CITY OF ALBUQUERQUE

**Re: Gracia Cadillac
1220 S. Renaissance
Traffic Circulation Layout
Engineer's/Architect's Stamp 02-21-20 (F16-D003I)**

Based upon the information provided in your submittal received 02-24-20, the above referenced plan cannot be approved for Building Permit until the following comments are addressed:

C-103

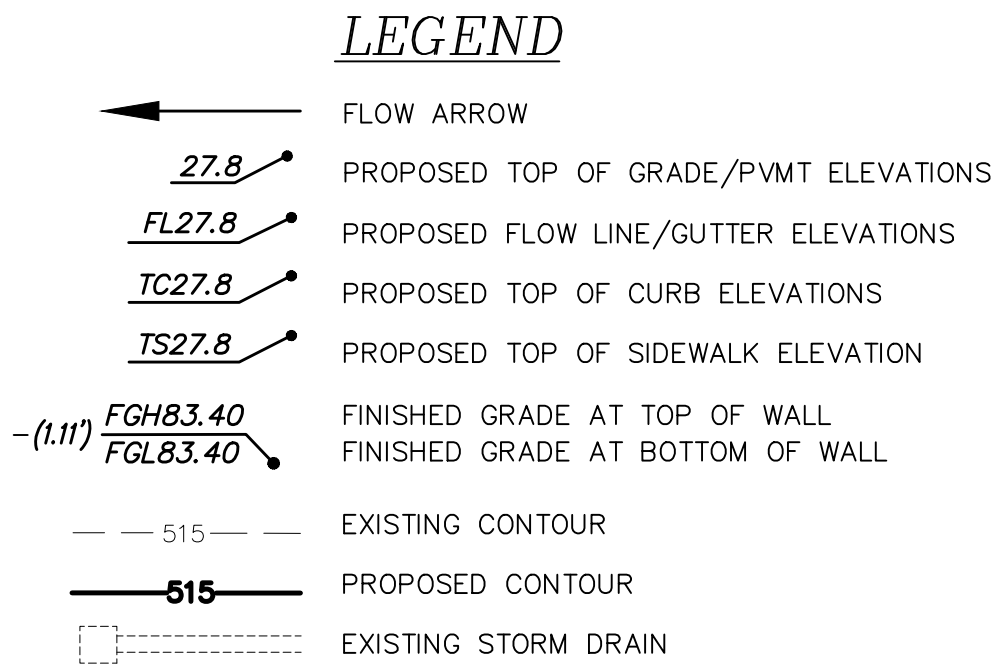
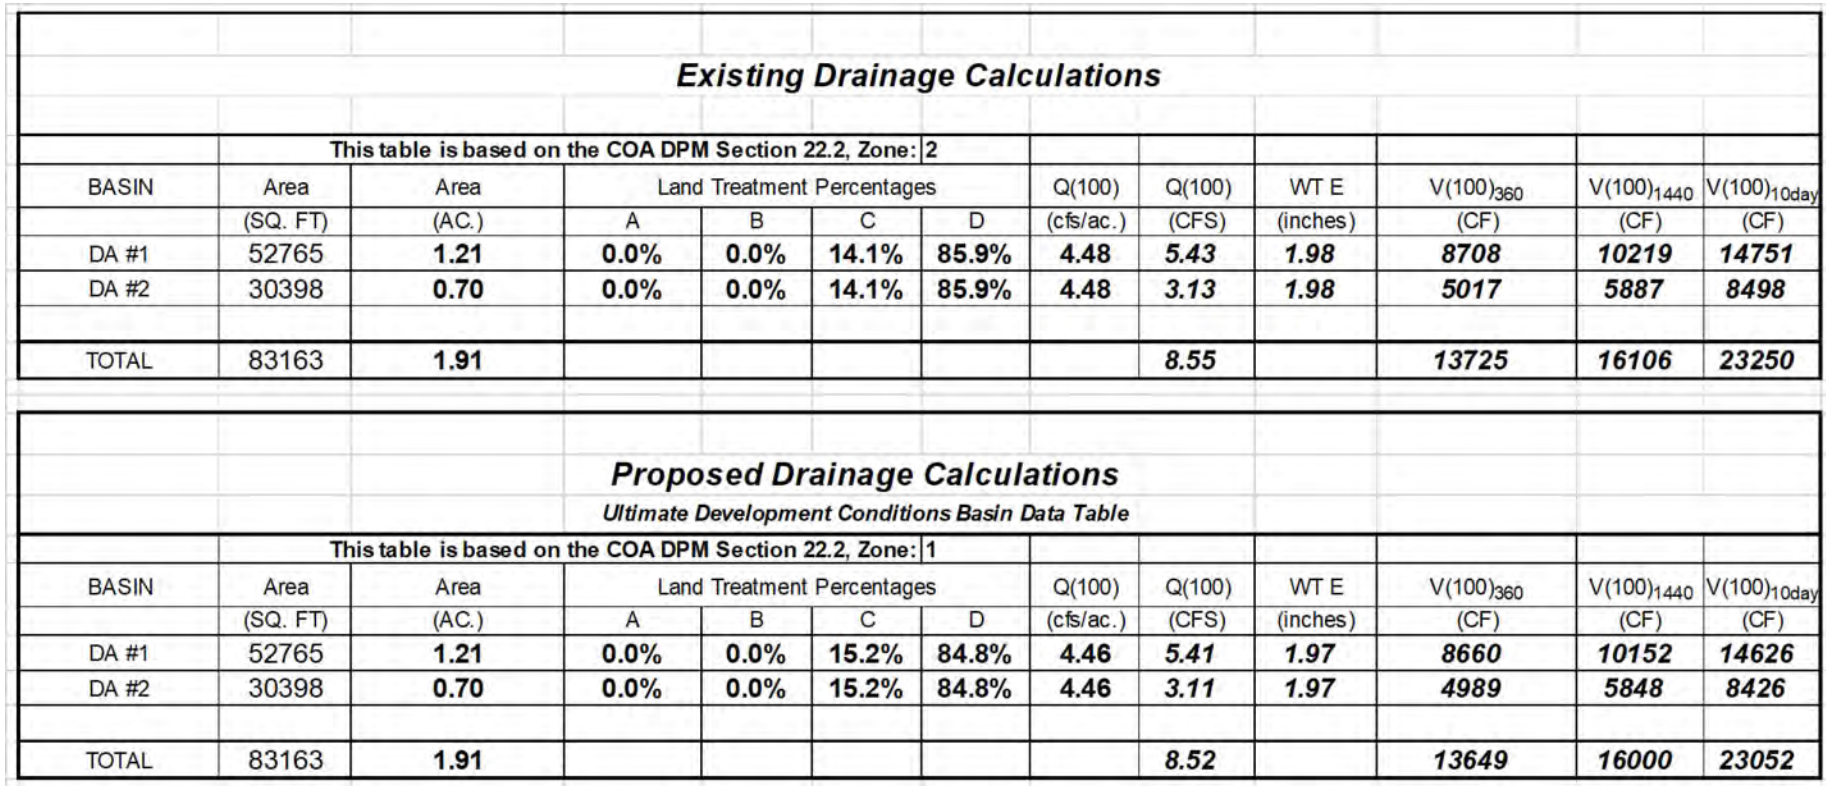
3. The sidewalk 5 ft. sidewalk parallel to Montbel needs to be tapered to provide a clear turnaround of 5ft by 5ft.
4. All bicycle racks shall be designed according to the following guidelines:

- a. The rack shall be a minimum 30 inches tall and 18 inches wide.
 - b. The bicycle frame shall be supported horizontally at two or more places. Comb/toaster racks are not allowed.

- c. The rack shall be designed to support the bicycle in an upright position. See the IDO for additional information.
 - d. The rack allows varying bicycle frame sizes and styles to be attached.

- e. The user is not required to lift the bicycle onto the bicycle rack.
 - f. Each bicycle parking space is accessible without moving another bicycle.

- g. **Proposed location is a safety concern. Please provide an alternate location.**
5. Bicycle racks shall be sturdy and anchored to a concrete pad.
6. A 1-foot clear zone around the bicycle parking stall shall be provided.

7. Bicycle parking spaces shall be at least 6 feet long and 2 feet wide.
